Application for a Non-Material Amendment Following a Grant of Planning Permission

Proposed new care home facility and creation of new access, car parking, boundary fencing, bin store enclosure and landscaping

DC/22/66779

21-09-26 Proposed elevations 1 rev I
21-09-27 Proposed elevations 2 rev F

Client	[REDACTED]	
Project Title	Care Rehabilitation units Narel Sharpe House Smethwick	
Drawing Title	Elevations 1	
Scale	Date	Sheet
1:50	21.09.22	A1
Author	Checked by	
RD	LW	
Job No.	Drawing No.	
21-09	26 M	
Status	CONSTRUCTION

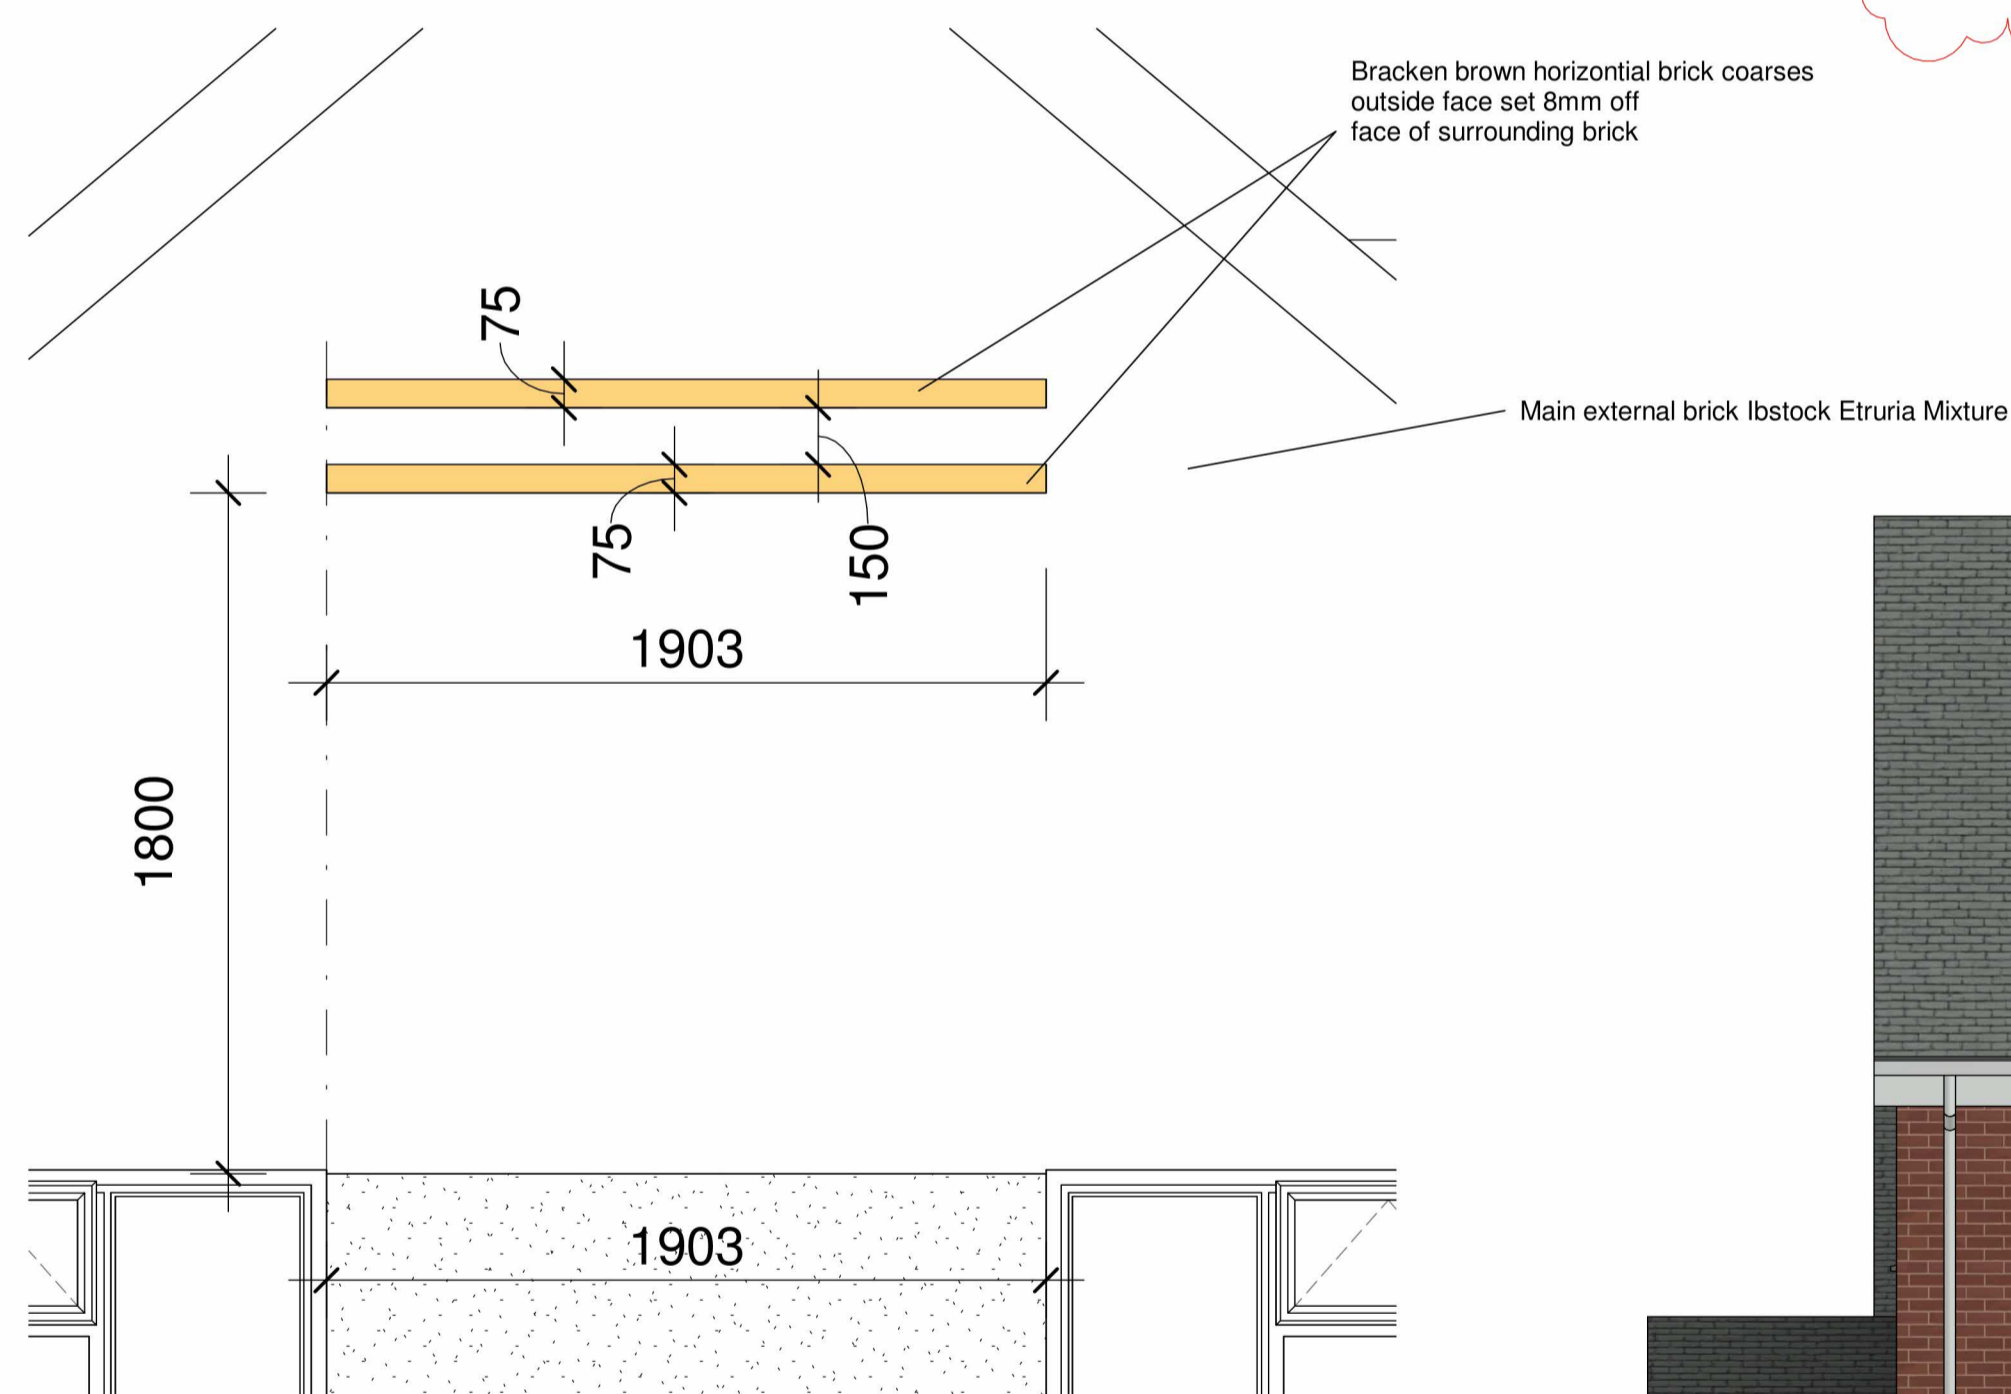
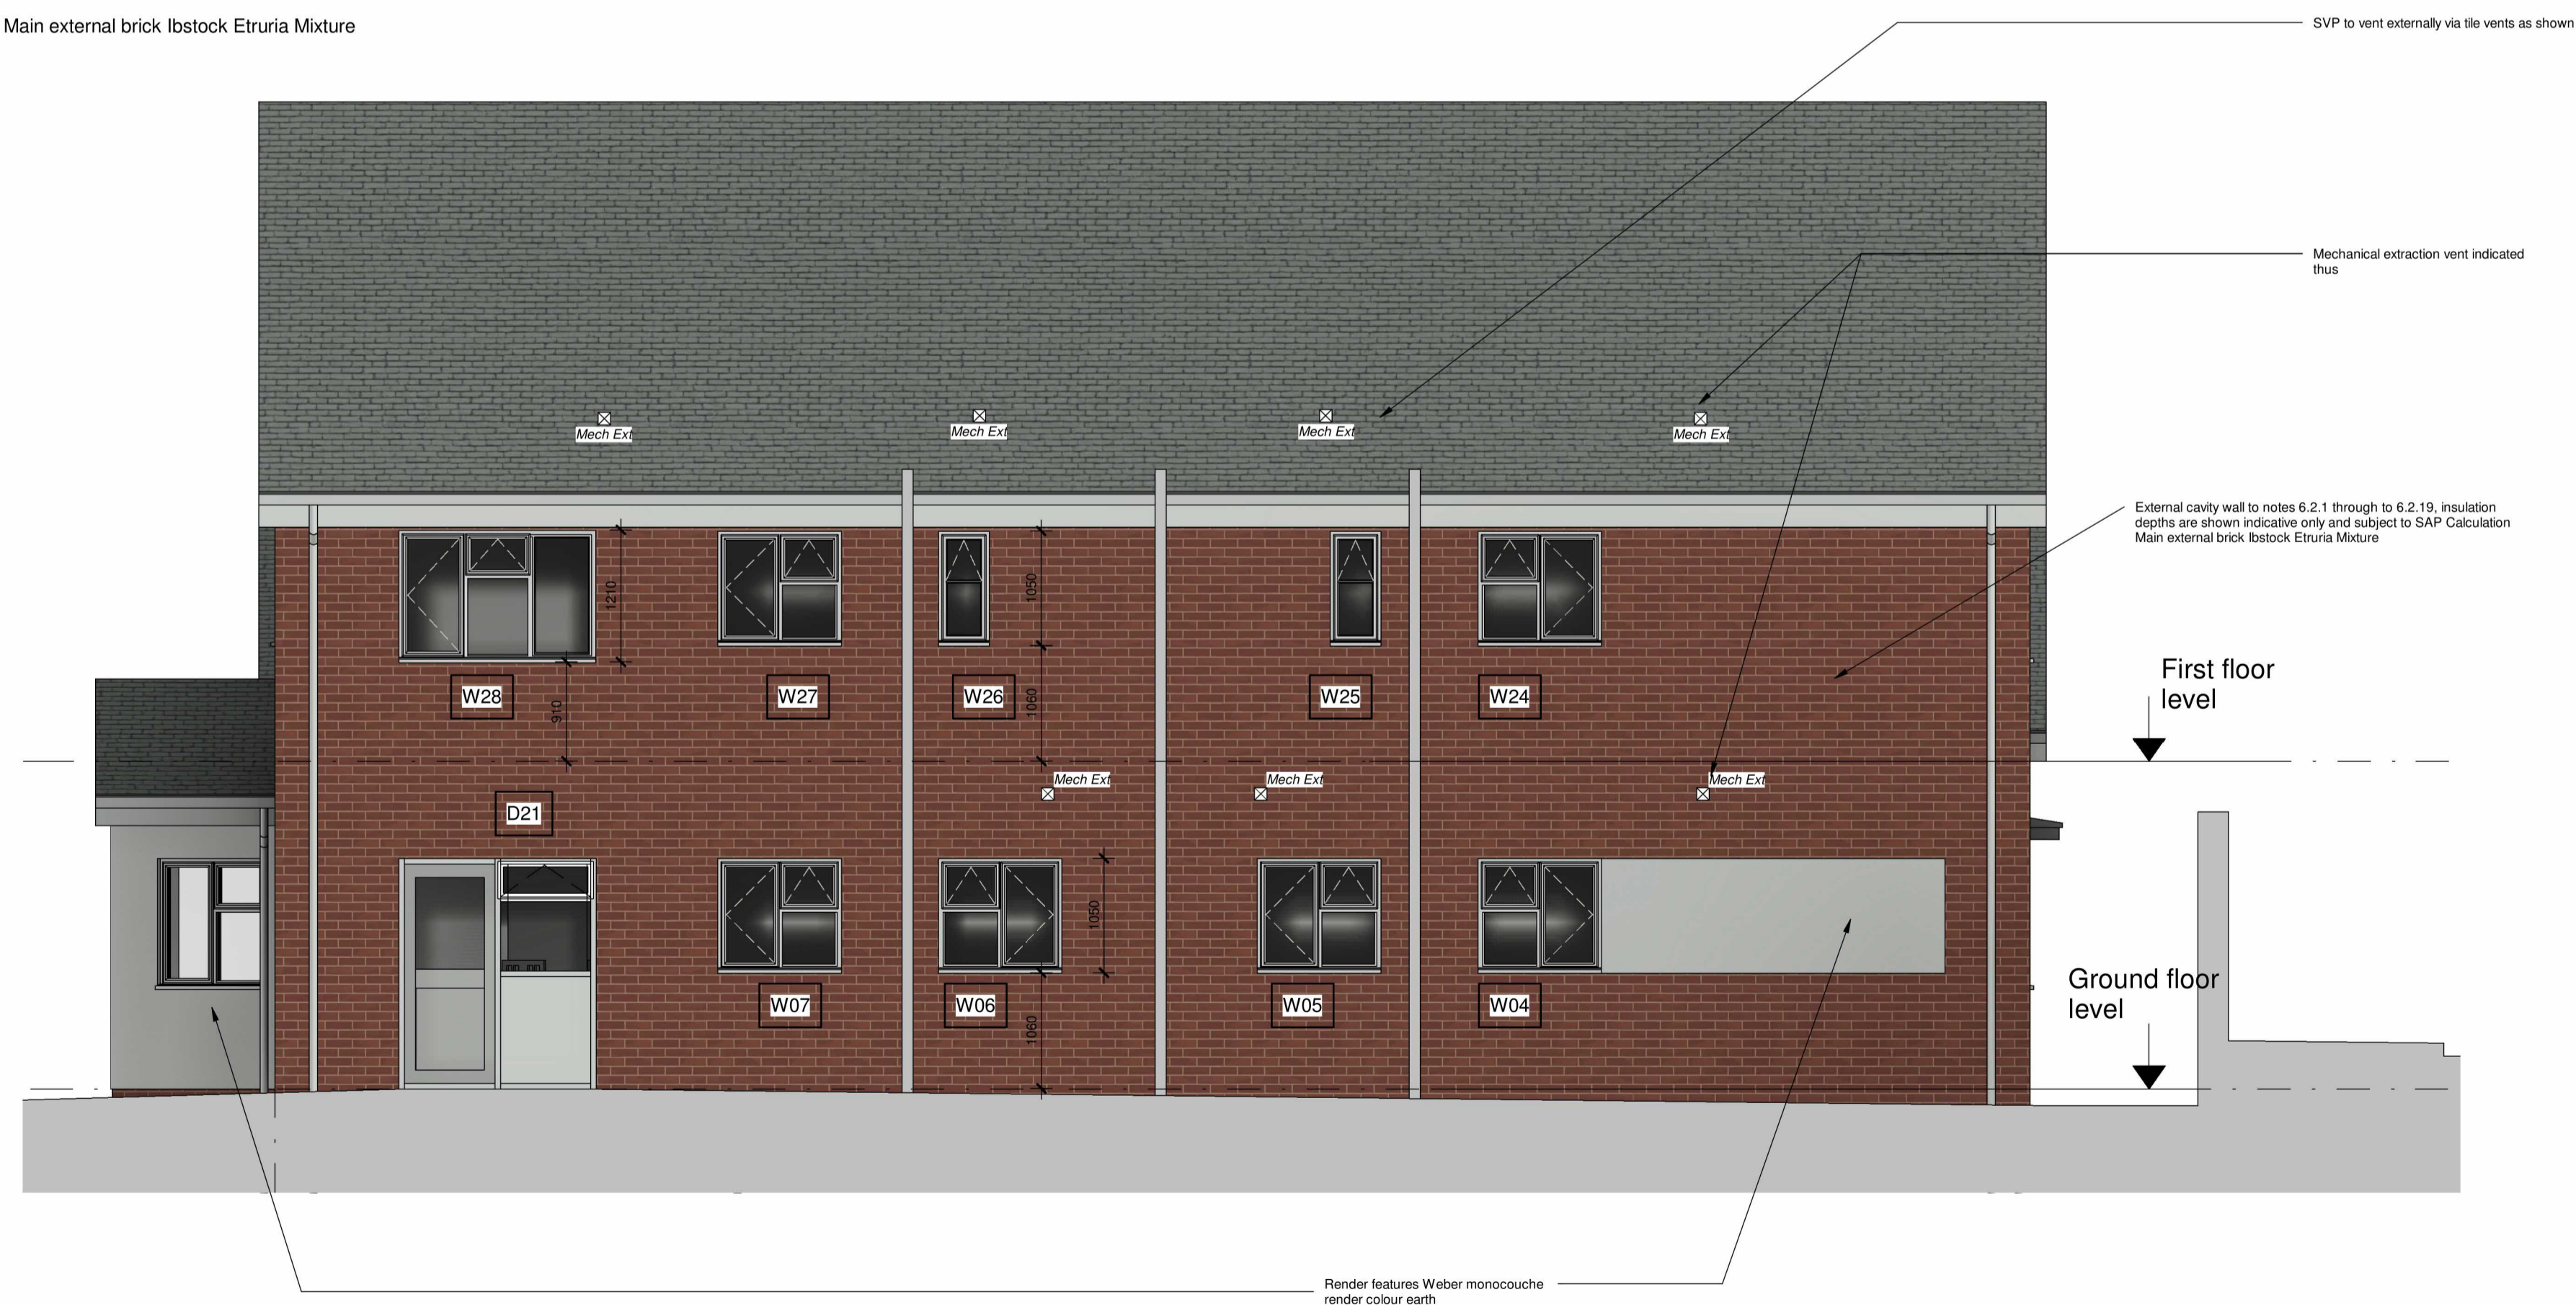
Change 1 = Two number windows to East elevation (W01 and W21) reduced in size, front door reduced to single door
Change 2= Two number windows to South elevation (W25 and W26) reduced in size, external soil pipes added, door reduced to single door
Change 3= Two number glazed double doors changed to one a smaller window and the other a smaller single door, external soil pipes added, brick and render feature detail added, door changed to single door
Change 4= Bin store moved closer to Chance Drive
Change 5= Front entrance canopy changed to flat roof GRP cantilevered type

Change 1 = Windows reduced to provide more privacy for the building users, door reduced to single type to improve door robustness
Change 2 = Windows reduced to provide more privacy for the building users, external soil pipes moved to outside to provide more accessible drainage, door reduced to single type to improve door robustness
Change 3= Glazed doors reduced to smaller window and door to provide more privacy to the building users, brick and render feature added to visually enhance rear wall, door changed to single door to improve door robustness
Change 4= To provide more enclosed rear garden space
Change 5= By using a cantilevered canopy (hung off front wall of the building) more space is provided around the entrance area because support columns have been eliminated
